**Consultation Response from KC,
Highways Development Management**

2021/91239 410/412, Birkby Road, Birkby, Huddersfield, HD2 2DN

Demolition of existing dwellings and garage and erection of two detached dwellings

Date Responded: 25/08/21 Responding Officer: CNB Responding Ref: K5-3NW/12

Proposed Site Layout Plan

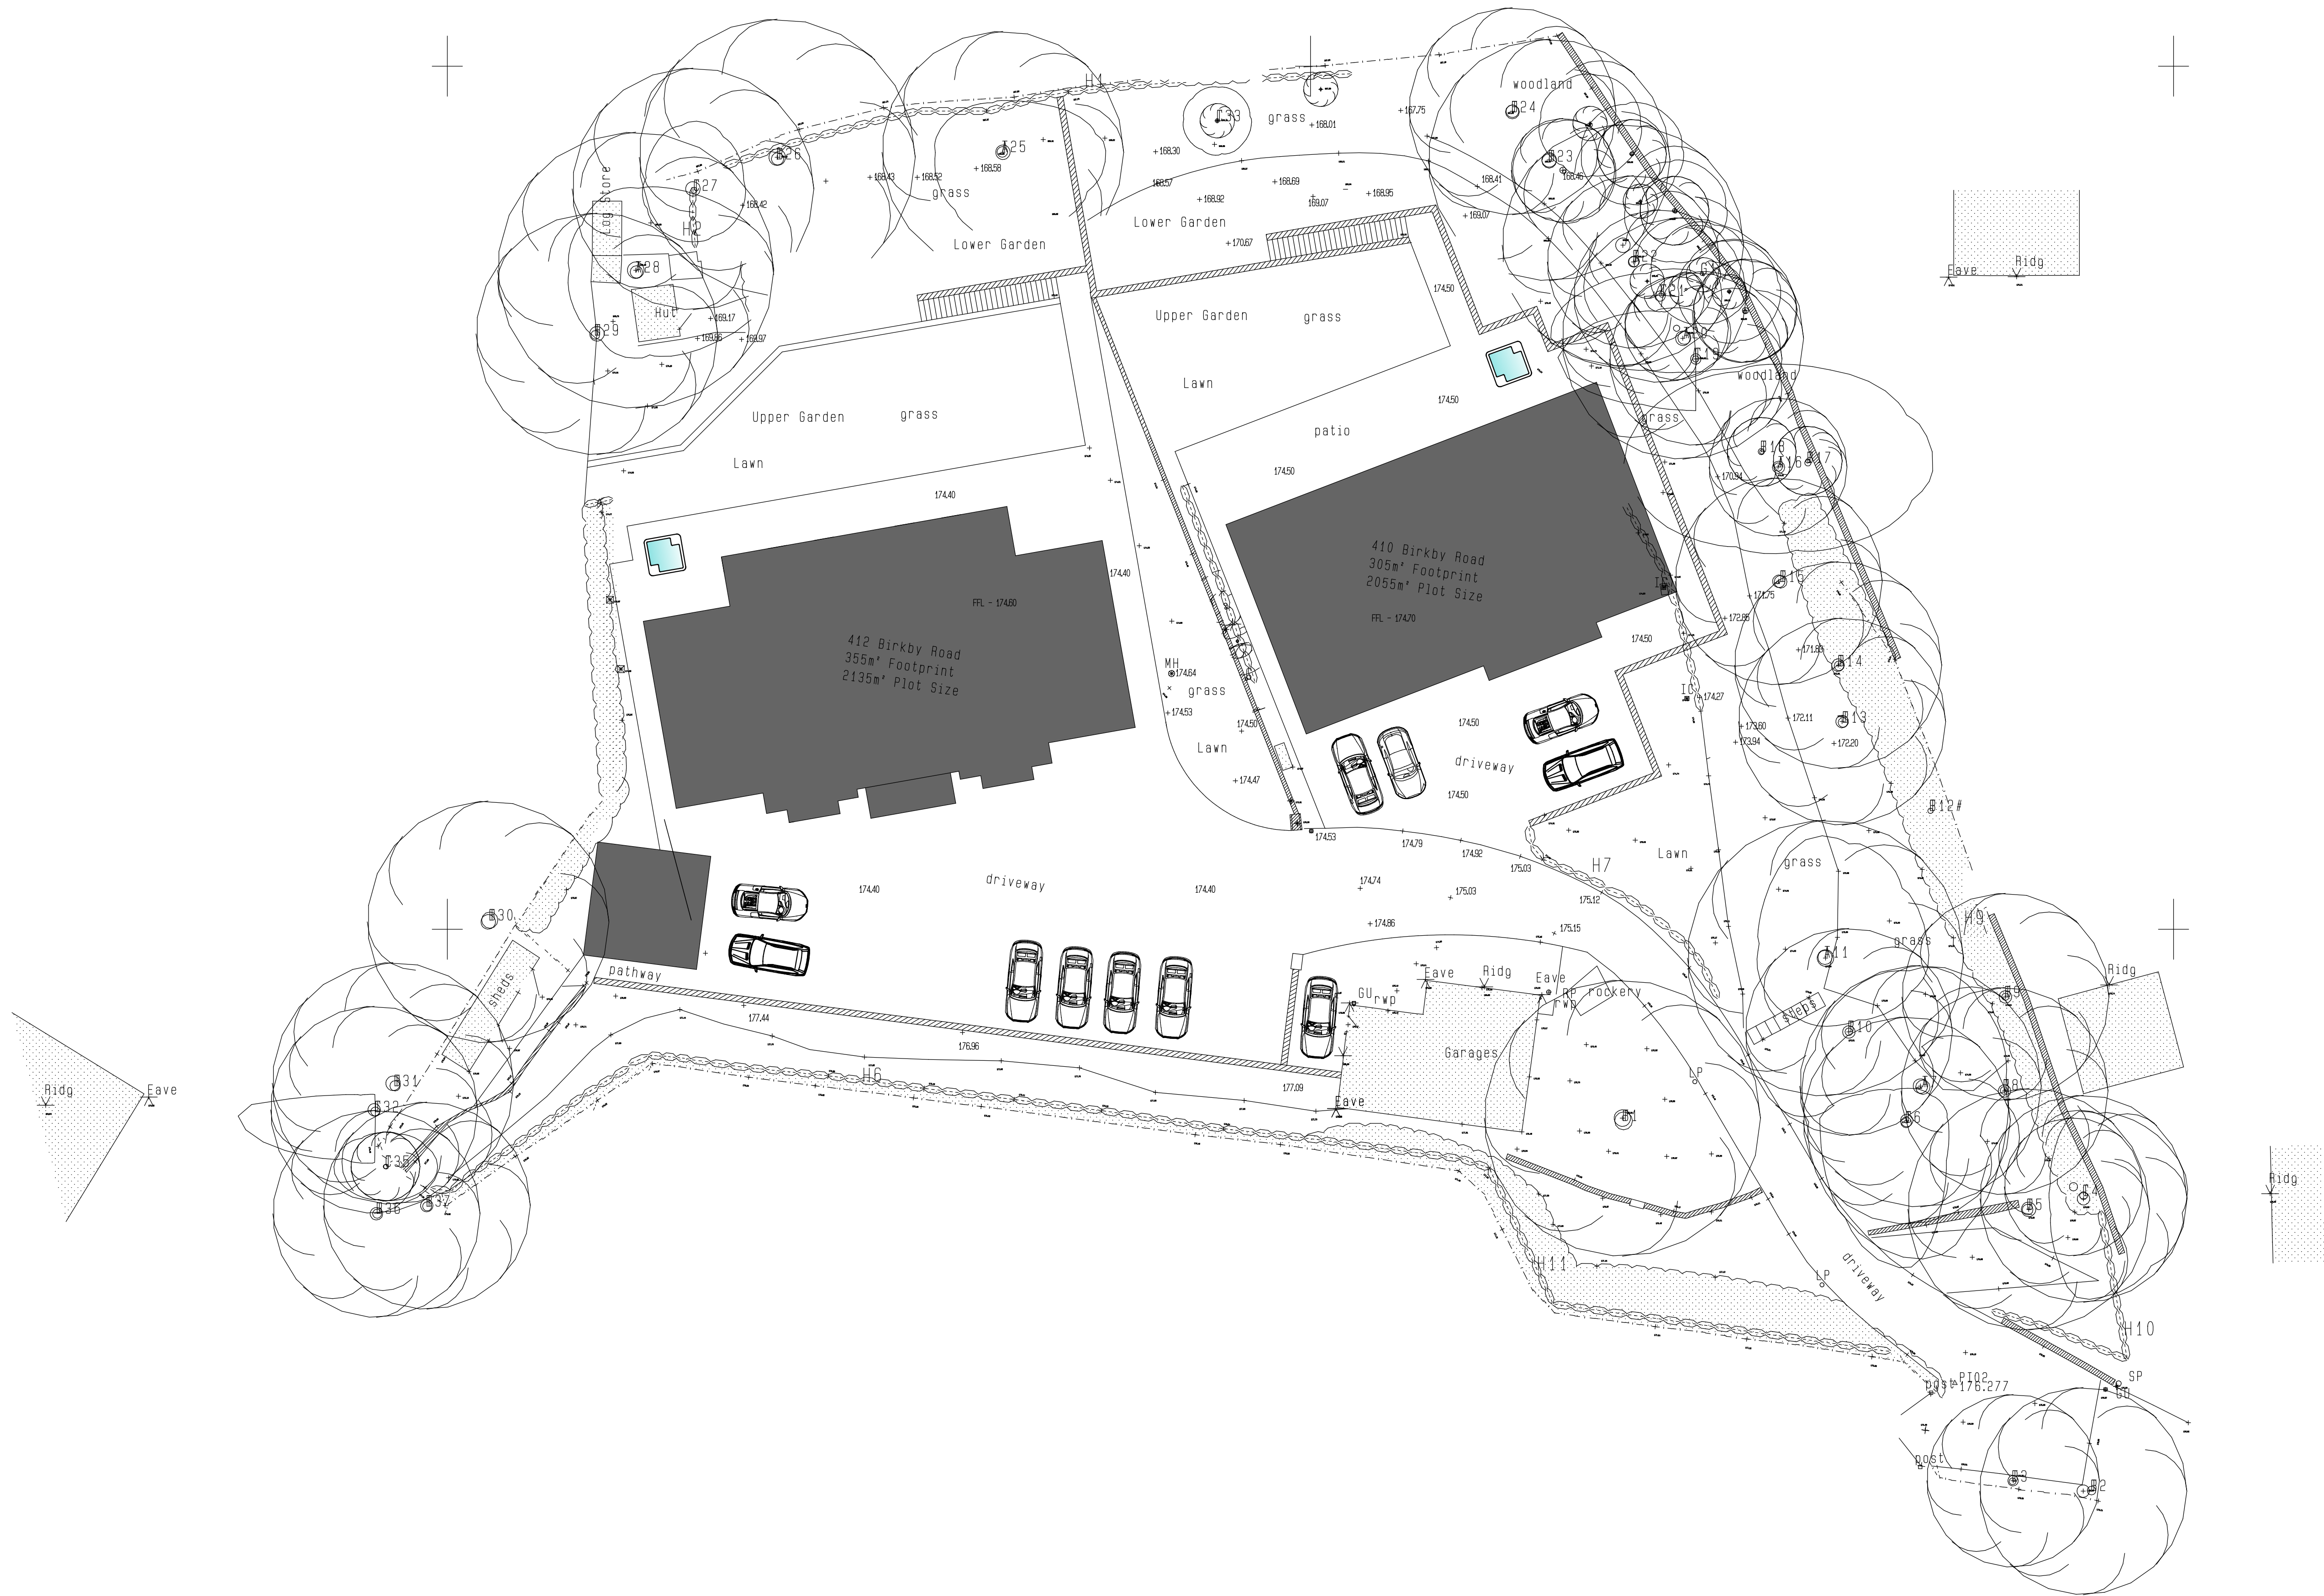
The number of parking spaces suggested in local guidance for this type and size of development would be three off road spaces per dwelling, drawing No 2121 05C showing sufficient space for approximately 14 cars with turning and manoeuvring space, including the three triple garages and driveway spaces. This over provision of parking spaces may be against council policy and the promotion of sustainable transport above use of the private car. However, this is not a concern that would make us object to the application.

No details were provided showing waste storage and collection to the sites, it is assumed that this would be done as at present, however we would like to see that the proposed layout can still allow for the safe storage of waste bins, that a collection vehicle can access the site and turn and that the relevant carry distances proposed in guidance can be adhered to. These should be clearly displayed on a drawing, and this should be conditioned.

Before development commences, details of suitable storage, bin presentation points and access for

collection of wastes from the dwellings hereby approved shall be submitted to and approved in writing by the Local Planning Authority. The approved details shall be provided before first occupation and shall be so retained thereafter.
